WELWYN HATFIELD COUNCIL – DEVELOPMENT CONTROL
DELEGATED REPORT

APPLICATION No:	S6/2007/1006/FP
------------------------	------------------------

The application seeks full planning permission for a first floor rear extension over the existing flat roof of a previous extension to a depth of approx 3.4m to provide a larger bedroom. A single opening is proposed in the rear wall which is for full height glazed doors to open onto a 'Juliette style' balcony.

DRAWING TITLE
 Proposed extensions to
 existing detached house

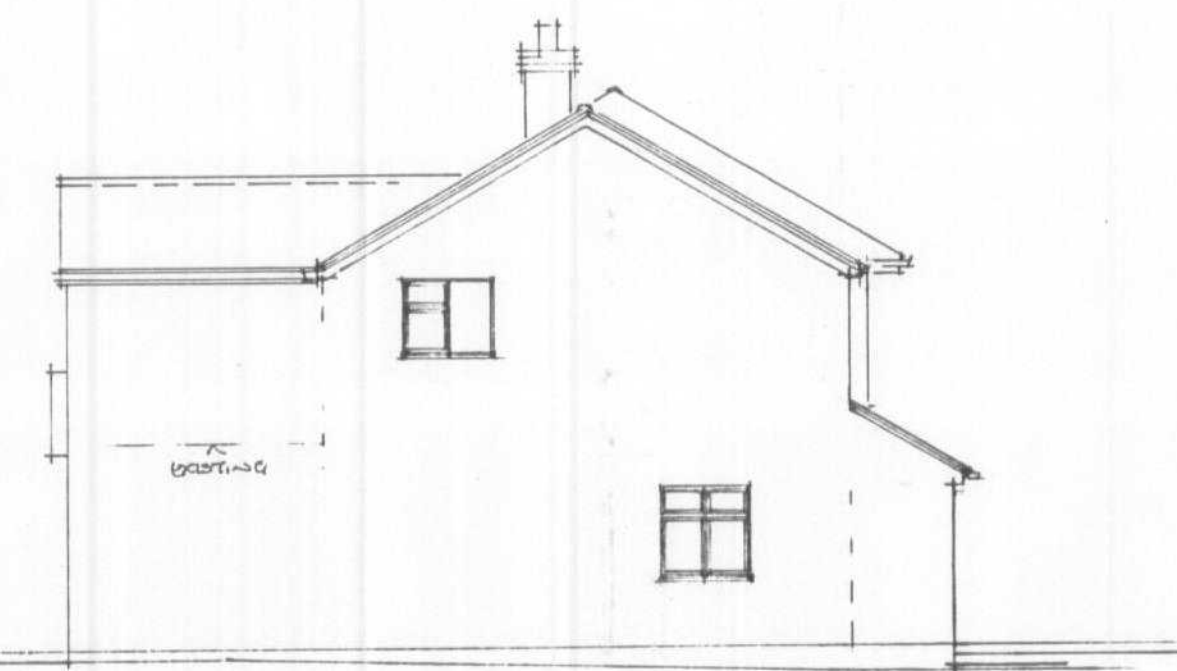
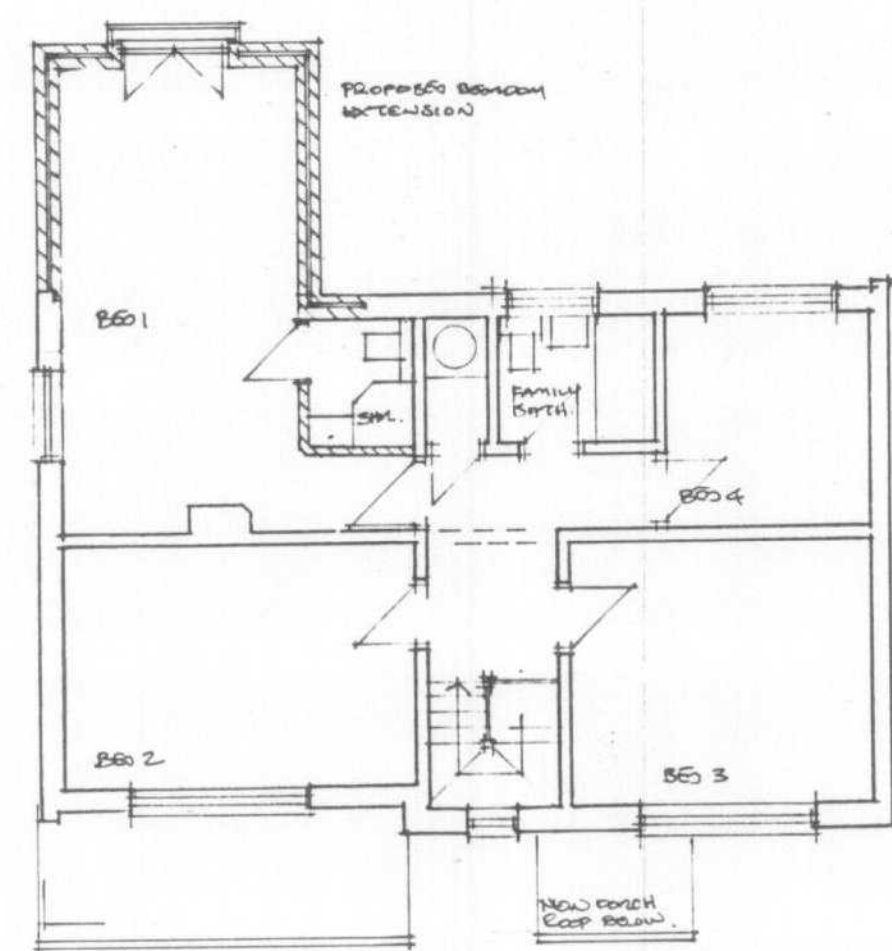
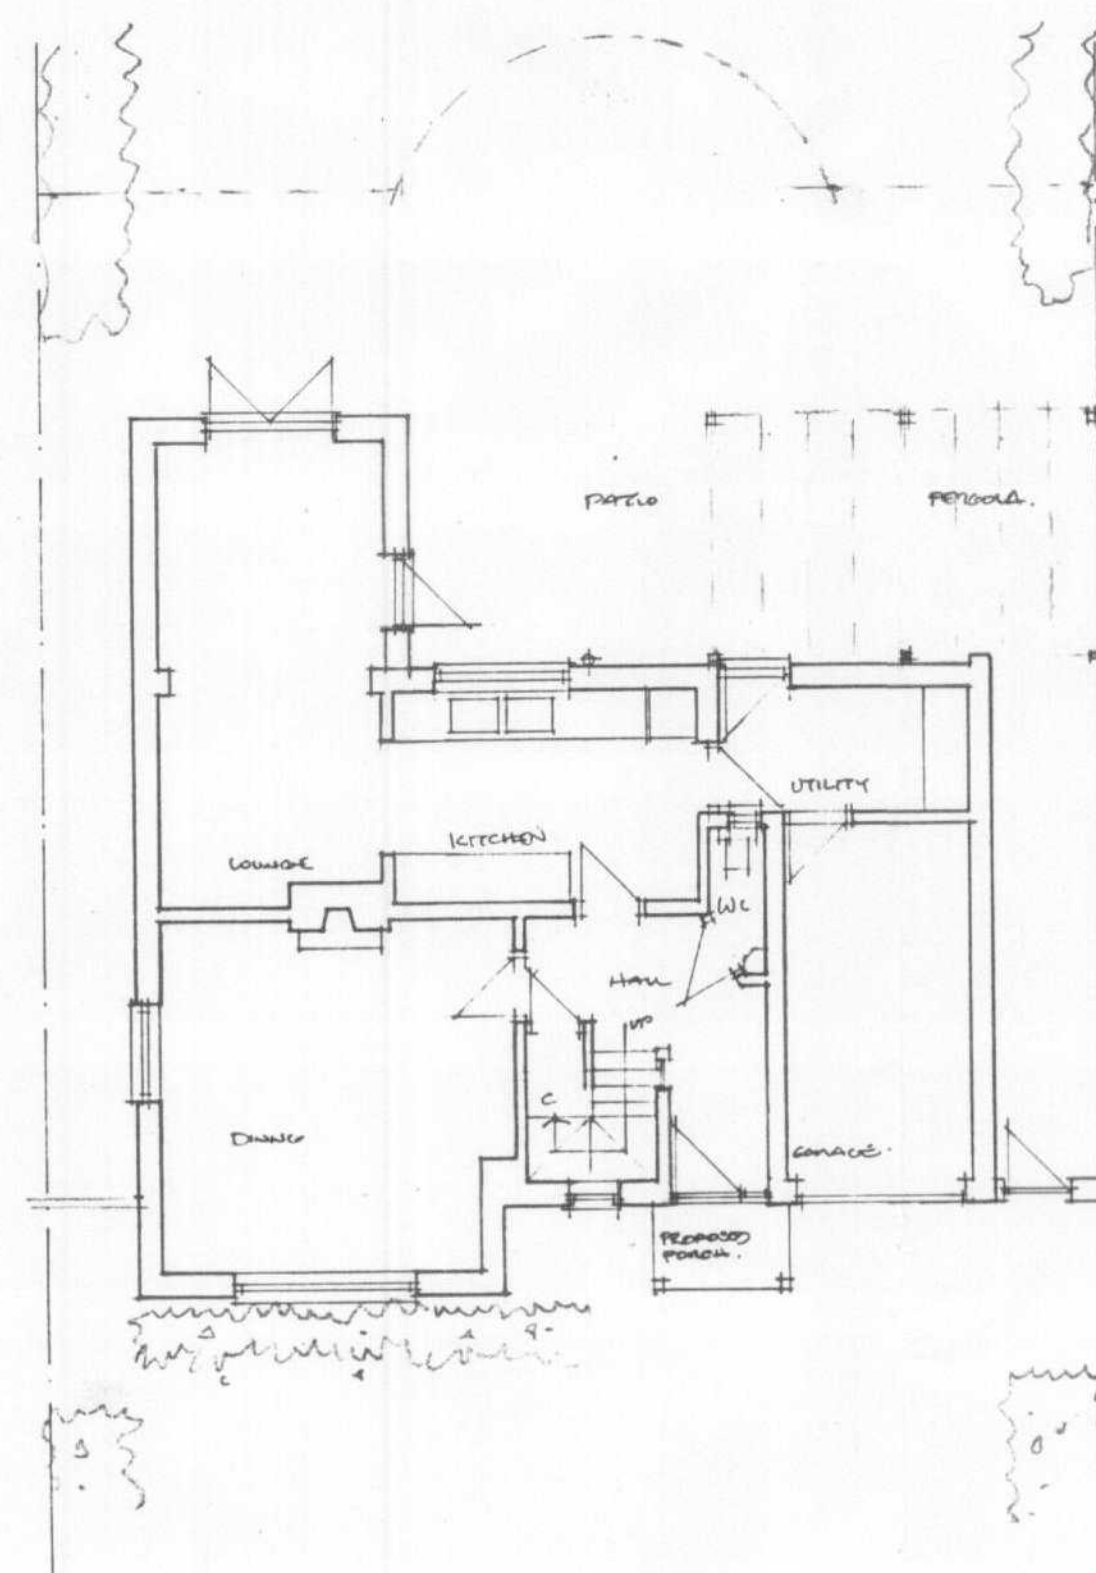
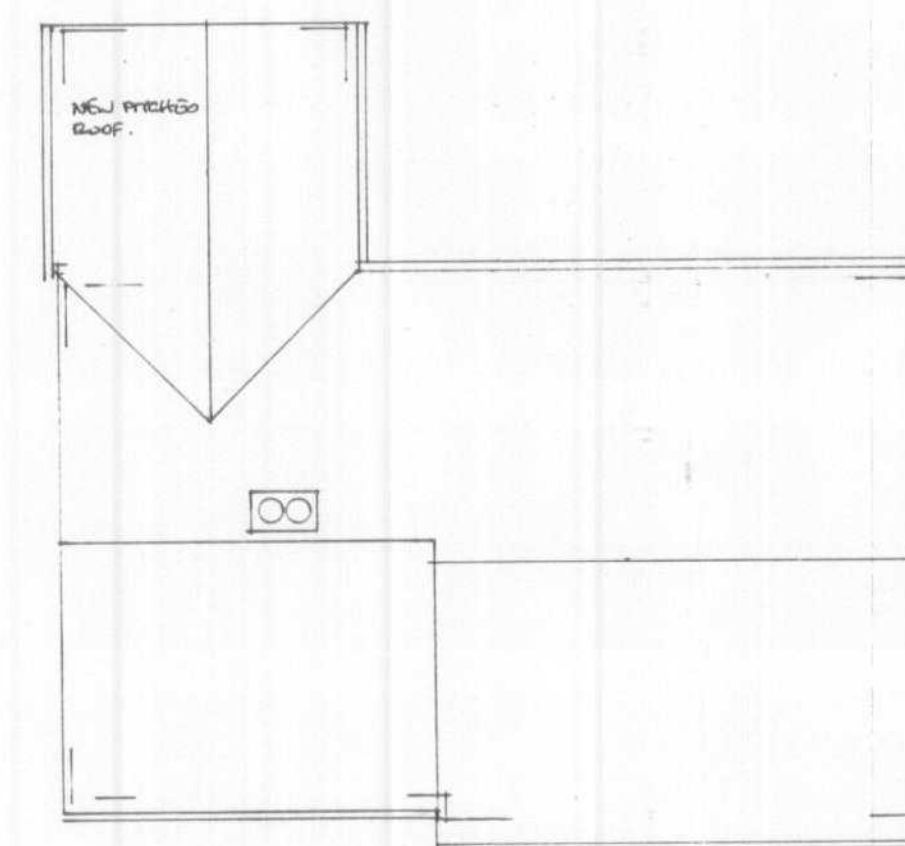
The drawings and application form refer to the new and existing walls to be 'colour washed cement/sand render'. The proposal appears to be to render the whole of the resultant building including the existing structure. The building is not located in a Conservation Area and is not a listed building and therefore permitted development rights normally exist to allow the exterior walls of buildings to be coated with a thin render. Bearing this in mind, it is reasonable to request that the proposed extension when first completed either matches the current building or that of the newly rendered building (if this is the intention) and so a condition agreeing the external materials should be attached.

and two storey rear extensions and so the impact on the rear private garden and rear windows of this adjoining property will be significantly reduced. It should be noted that the site location plan on the submitted drawing does not show the existing rear extension at No.30. There is a first floor side window to No.30 which was originally a bathroom window, and although some light will be lost to this window, a reasonable level will still remain. An original first floor rear bedroom window also exists to No.30, and although the new extension will have some impact on this window, the separation of this window from the common boundary is sufficient to ensure that a reasonable level of light would still remain.

Finally, a 'Juliette style' balcony is proposed which would overlook the rear garden of the application property. Although limited oblique views may be possible towards the rear garden of No.30 it is considered that these would be very limited, particularly as there is no platform to the balcony to walk onto. The balcony would therefore not result in any undue loss of privacy to this adjoining neighbour.

1. C2.1 Standard Time Limit – 3 Years
2. The tiles to be used in the construction of the extension hereby permitted shall match those used in the existing building. The proposed external finish to the rear extension hereby approved is to be agreed with the Local Planning Authority in writing prior to the commencement of works and shall be implemented in accordance with this approval.

3. Other than the windows shown on the approved drawings to which this planning permission relates, no windows shall be inserted into the side elevations of the first floor rear extension hereby permitted without the prior written consent of the local planning authority.
